**WEST SUSSEX COUNTY COUNCIL
INFRASTRUCTURE CONSULTATION**

SUBJECT: R/179/09

126 Sea Lane, Rustington

Amendments to planning permission R/283/07 – Relocation of parking and turning area utilising existing access onto Sea Lane

BLOCK PLAN 1/500

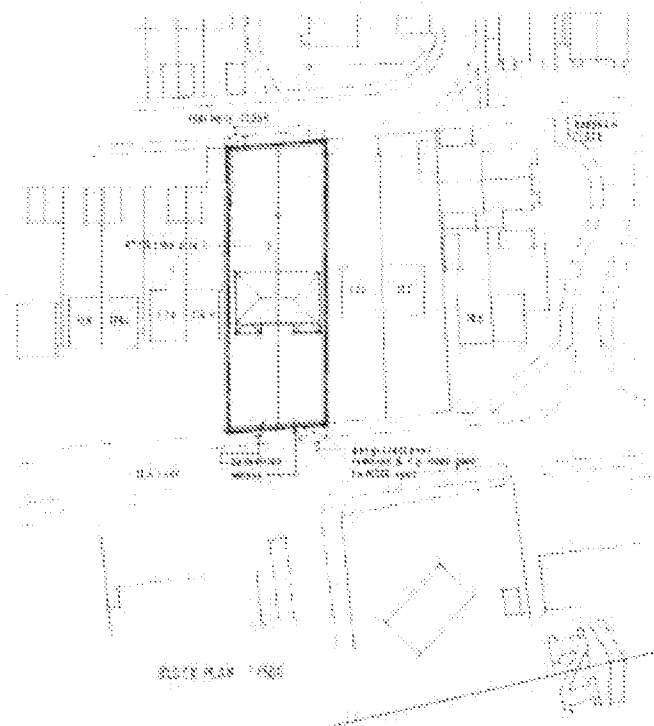
The proposal is for 2 dwellings utilising an existing crossover with access onto Sea Lane, however it would not appear that the access is currently in use as no hardstanding is present. From an inspection of the plans alone it is apparent that the turning arrangements are sub standard, and therefore WSCC would require the applicant to submit a new plan showing acceptable turning arrangements such as a swept path diagram. The applicant is advised that a minimum distance of 6m is required behind a parking space in order for a car to turn safely.

The proposed parking layout is not ideal, however providing vehicles can turn within the site and exit in a forward gear a highway safety issue is not anticipated to arise as a result of this arrangement.

In summary, WSCC would require a modification to the turning arrangements in order to address potential highway safety issues at this site.
